LANDSCAPE
MELROSE PARK SOUTH

RESPONSE TO SUBMISSION

OPEN SPACES - WEST SITE
MELROSE PARK SOUTH

Melrose Park South - West
OS4

Drawing No. Drawing Name
L- 403 OS4 Softworks Plan

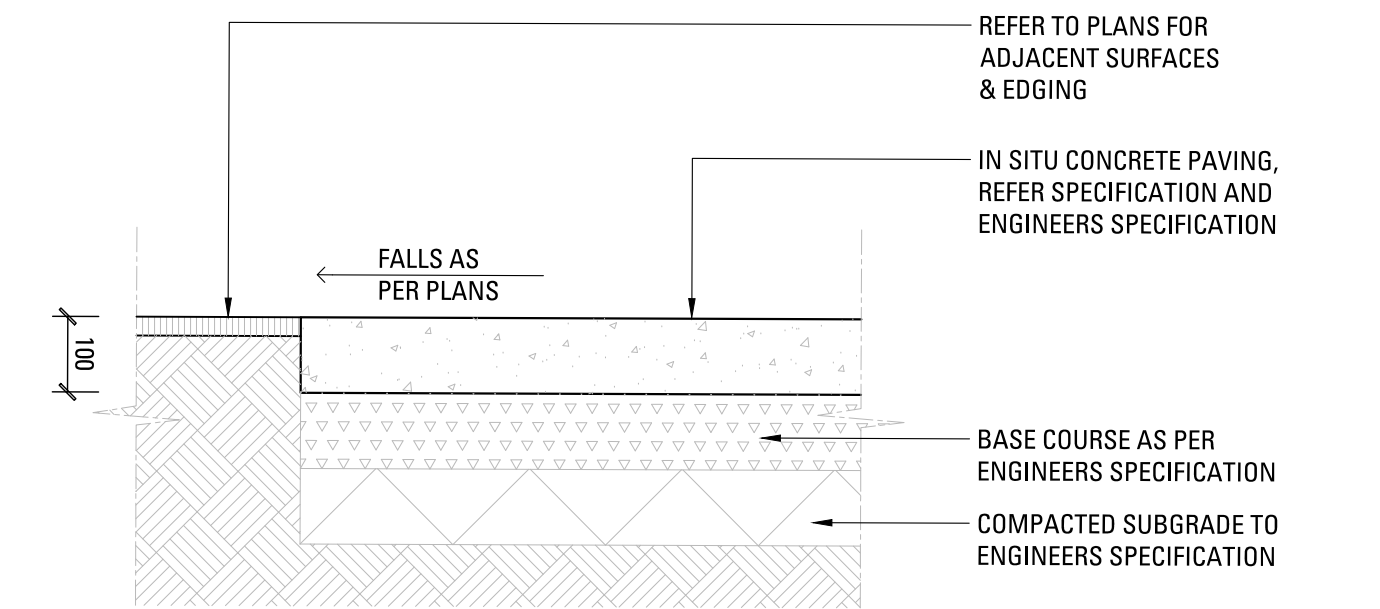
- + Council requests that Pennisetum sp. be replaced with Poa labillardieri and/or Poa poiformis as Pennisetum is an undesirable species in this location.

- + Maximum grades of 1:5 (Turf) and 1:3 (Garden beds) should be provided (and confirmed by showing levels on plans) to facilitate safe maintenance access. In addition, turf zones require minimum 2m clearances to pathway edges for mower access.

- + All trees should accommodate adequate setbacks to pathways and other infrastructure to minimise potential rootzone / canopy conflicts.
- + No turf should be provided within vegetated riparian zone to protect ecological and hydrological integrity (conflicting plans i.e. 'Materiality' versus 'Programme').

- + Pennisetum and Poa have been removed from the revised plant list and substituted with other species from these PCTs.
- + Please refer to SSDA-MPS-OSW-L-400 for revised plant schedule.

- + Grades of turf areas and garden bed do not exceed CoP's maximum grades. Additional levels on plans have been provided. Please refer to respective open space plans.

- + Proposed tree locations have been reviewed and adequate setbacks provided (minimum 2m offset from pathways). Please refer to open space plans in appendix.

- + Proposed turf areas have been removed from riparian corridor offset zones. Please refer to open space plans in appendix.

OPEN SPACE OS4

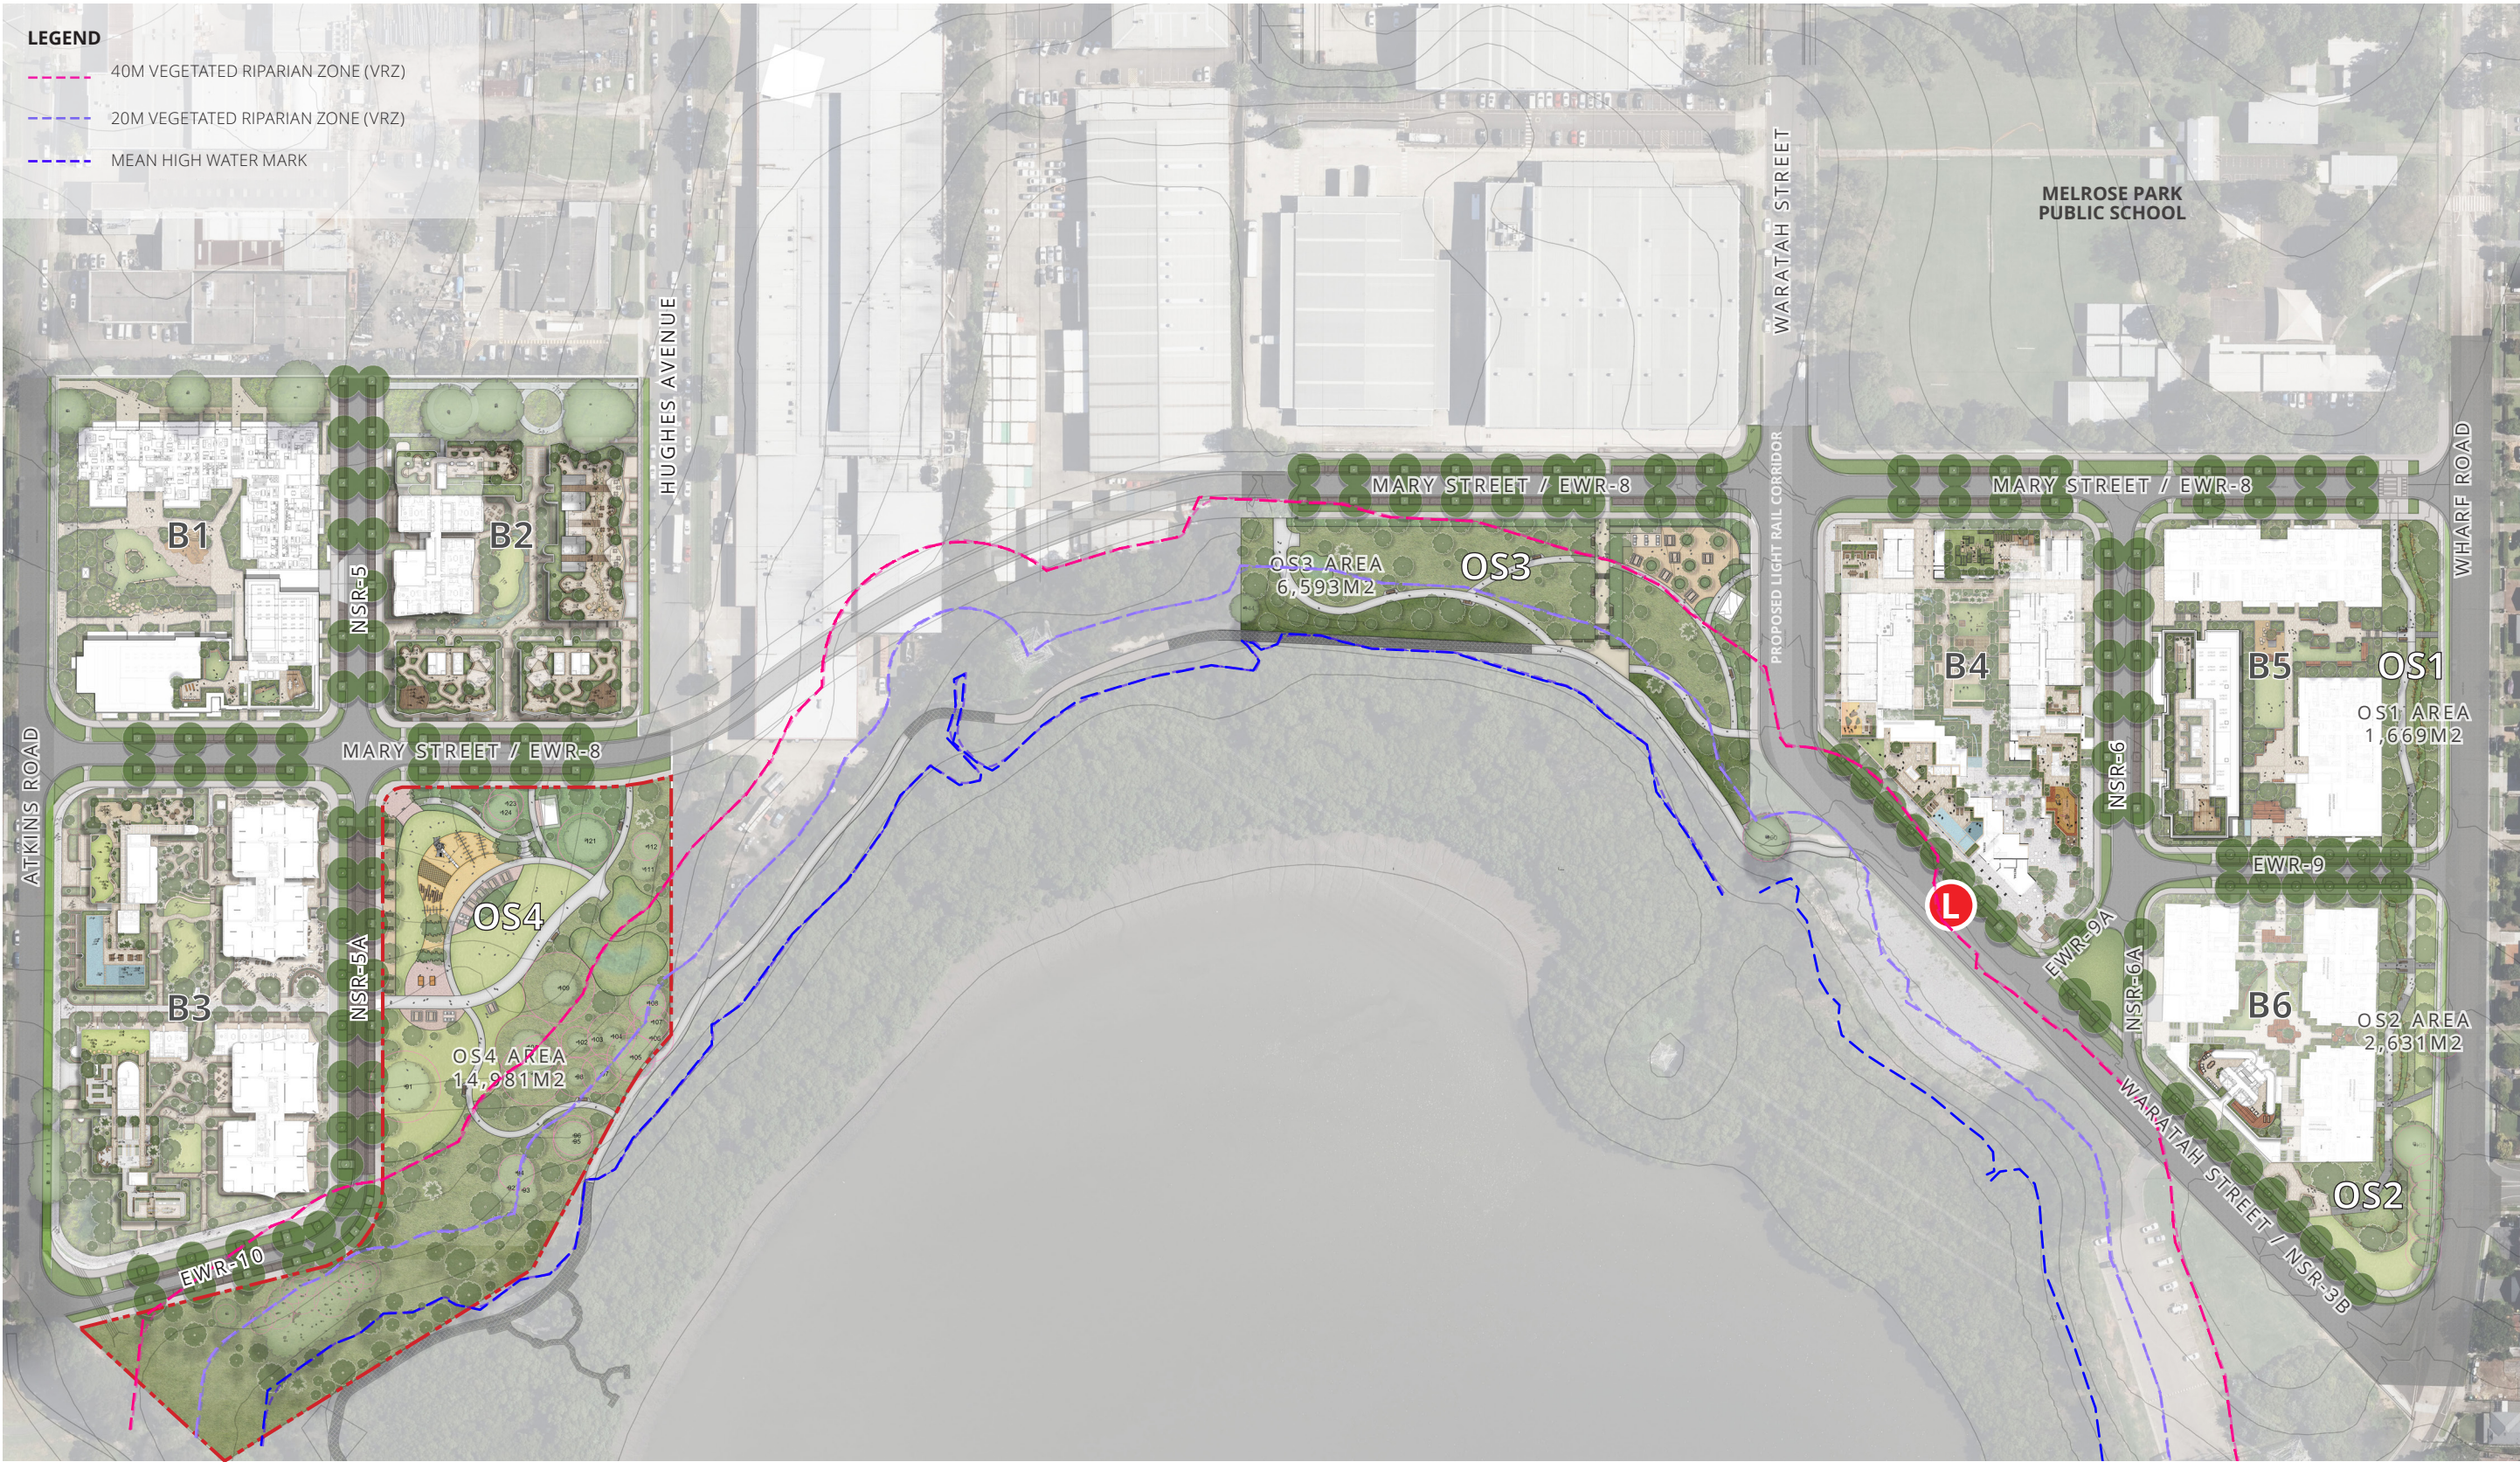
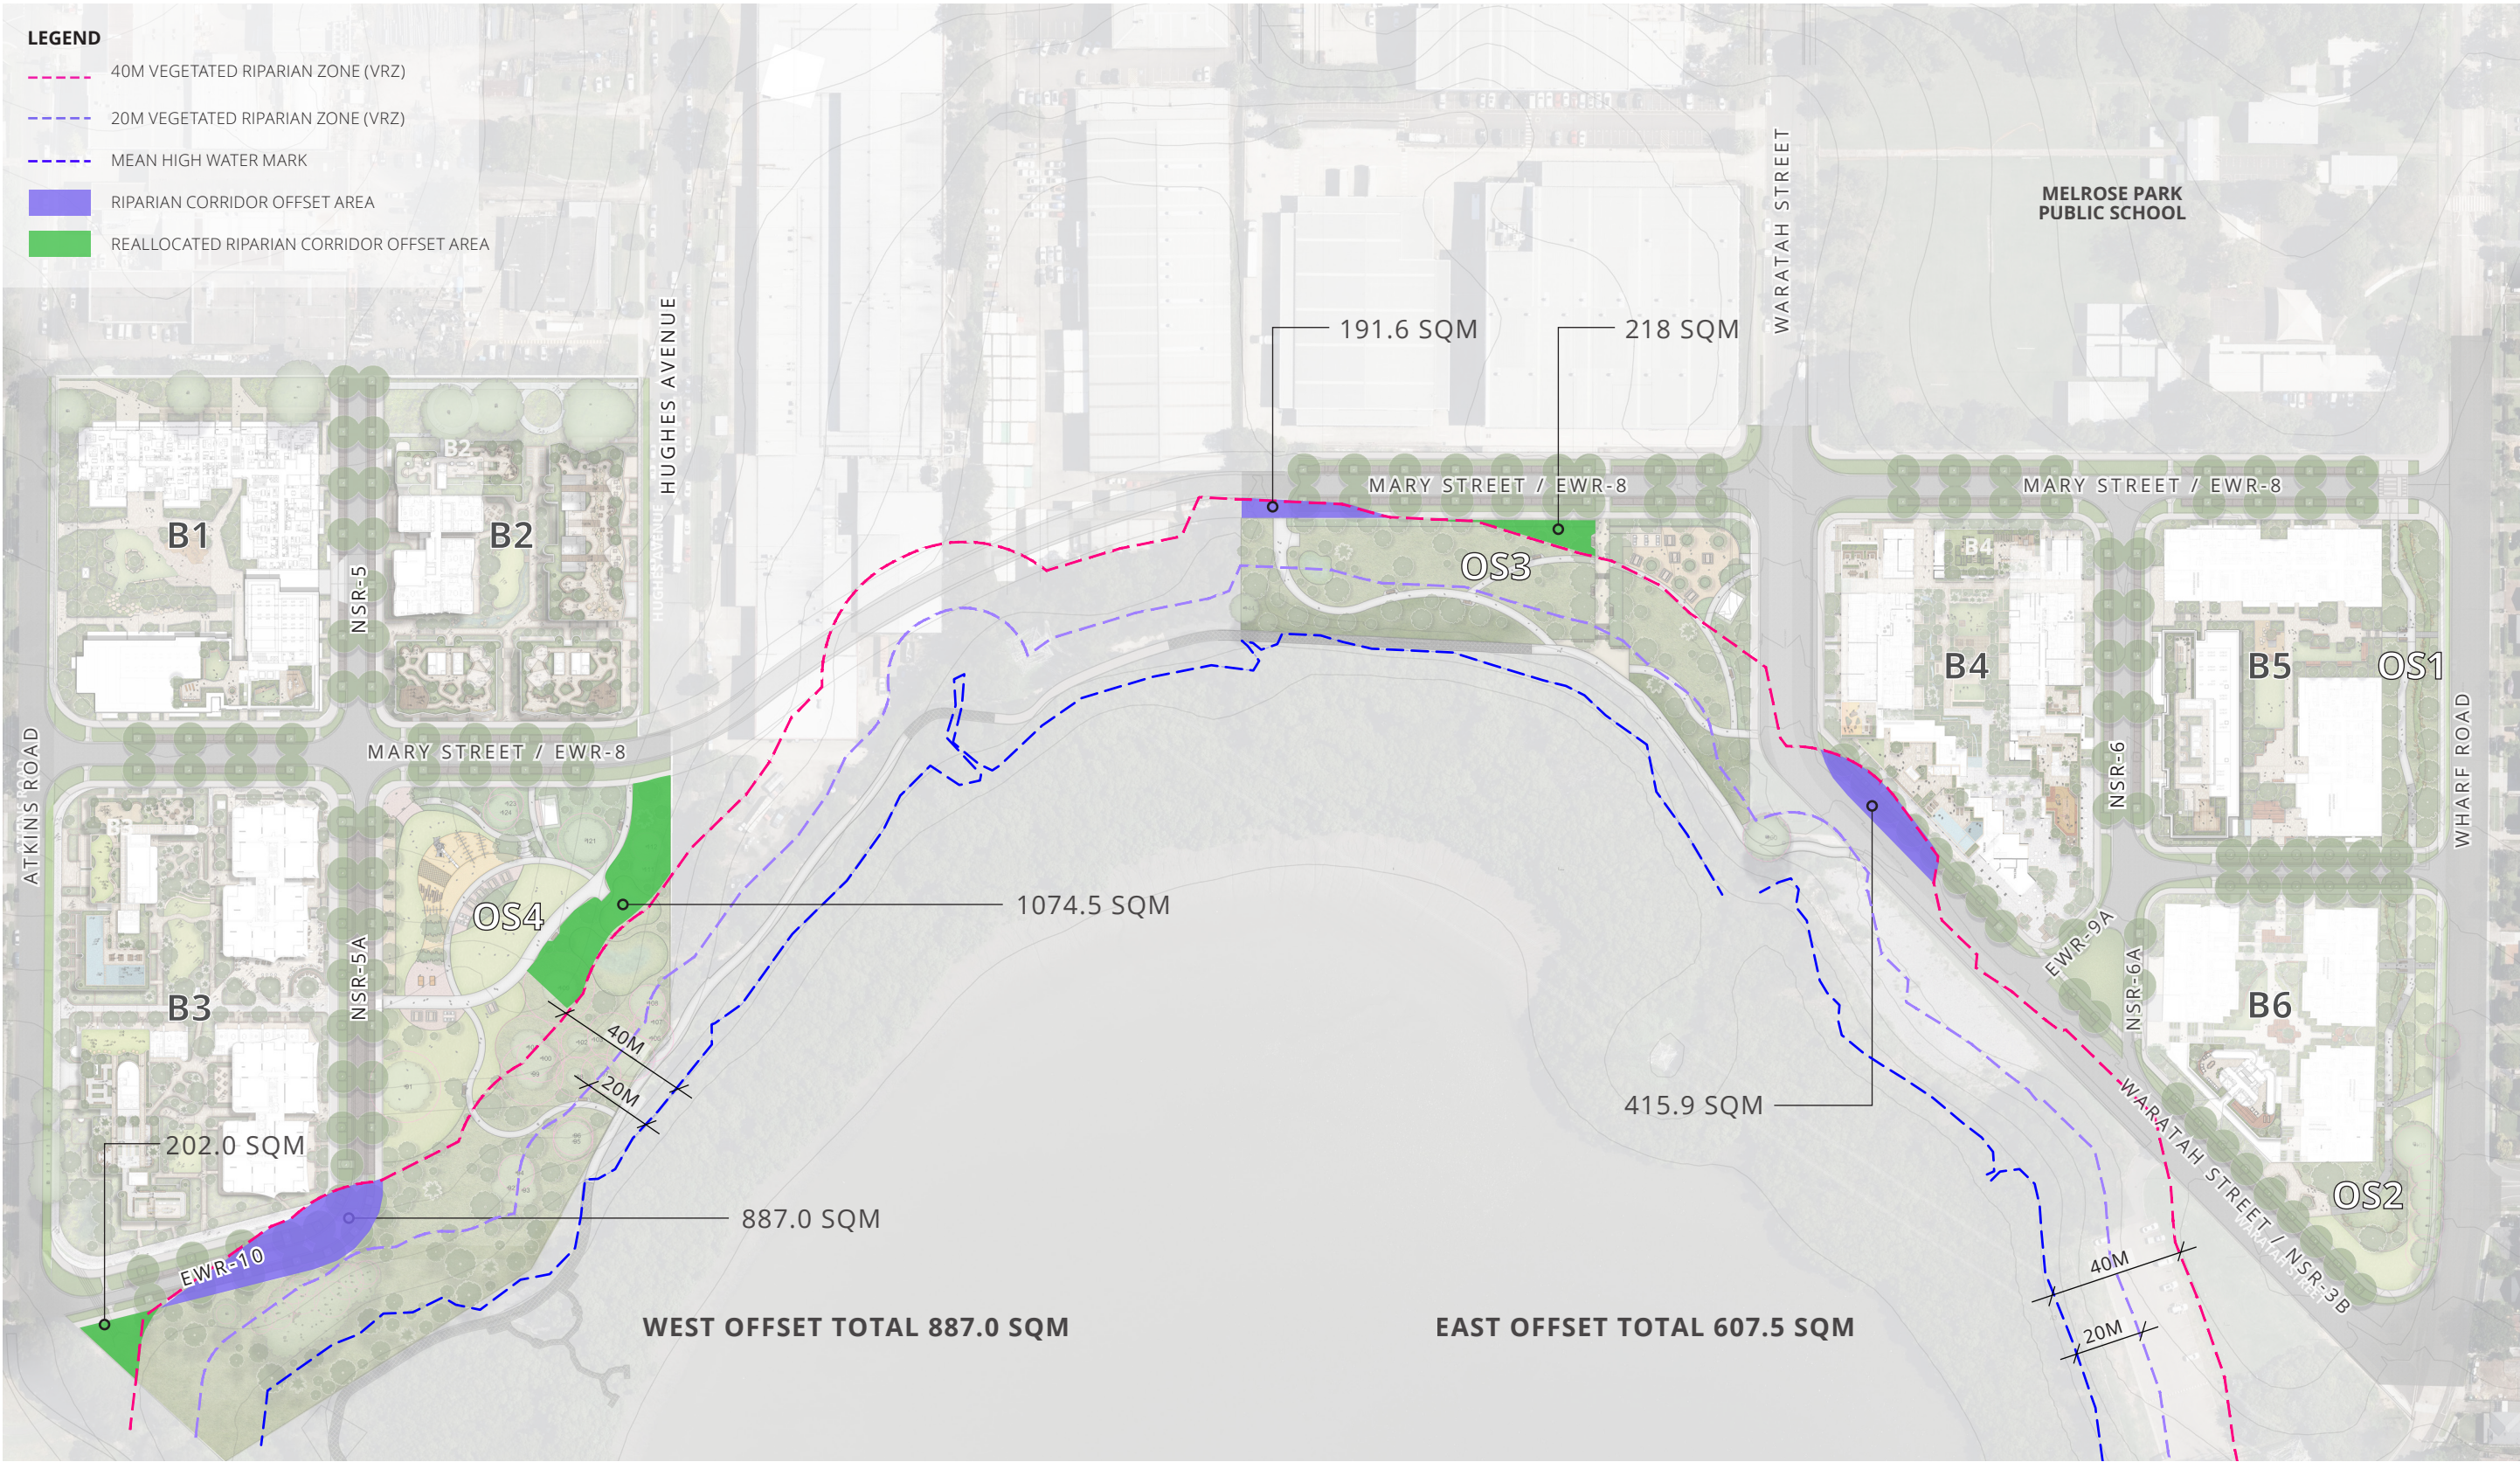
- + Council requests sections be provided at regular intervals through the park to clearly illustrate levels (e.g. turf area, embankment) and infrastructure (e.g. retaining walls).

- + All pathways should align with the street network and pedestrian linkages from adjacent communal open space to provide visual connections that minimise wayfinding signage requirements (i.e. northern entry to Hughes Avenue and western boardwalk to Block 3 communal open space).

- + Pathways should be used to define edge between turf area and riparian revegetation zone consistent with Open Space 3 to the east (i.e. connection from EWR-10 to boardwalk access path).

- + Council also requests that the proponent provide paved connections between park corner entry and playground Softfall zone for accessibility.
- + The BBQ area should be consolidated and relocated away from amenities building and include shelter(s) over the BBQ area (see figure below).

- + OS4 should have the western entry align directly with the internal link of block 3 (currently it looks offset by a few meters), and the northern main entry should sit directly across from the pedestrian crossings to Hughes Avenue.

- + Reconsider placement of play equipment in OS4 to avoid blocking a sightline where topography has created vantage point to water.
- + Equally consider which items within the public domain would benefit from a more discreet location. This would include BBQ areas, bins and the amenities block.

- + OS4 design has been reviewed, with additional information and design changes made. Summarised below and in side-by-side comparison on the following page:
 - + Additional landscape sections provided (please refer to appendix)
 - + Pathways realigned (where necessary) to align with the wider street network and other pedestrian linkages. Pathways re-routed to avoid existing tree TPZ zones.
 - + Provision of paved connection to play zone.
 - + BBQs moved and co-located with picnic shelters.
 - + Amenities block repositioned away from existing tree TPZ zones.
 - + Proposed trees reviewed and repositioned to align with amended design.
- + Please refer to detailed plans in appendix.
- + Ongoing design consultation with Council will occur during and after detailed design phase to ensure alignment with Council's feedback, VPA objectives and the 'Everyone Can Play' guidelines.

- + Most recommendations within comment 43 have been addressed in the revised RTS plan, including:
 - + Rationalising the hierarchy of pathways in and around the park.

- + OS4 Western entry pathway to Block B3 realigned to B3 planter edge.
- + Confirming the OS4 design includes considerations for:
 - + precinct-wide sightlines

- + alignment with the street network and other through-site links.
 - + proposed play equipment and landscape levels does not block sightlines to the water.
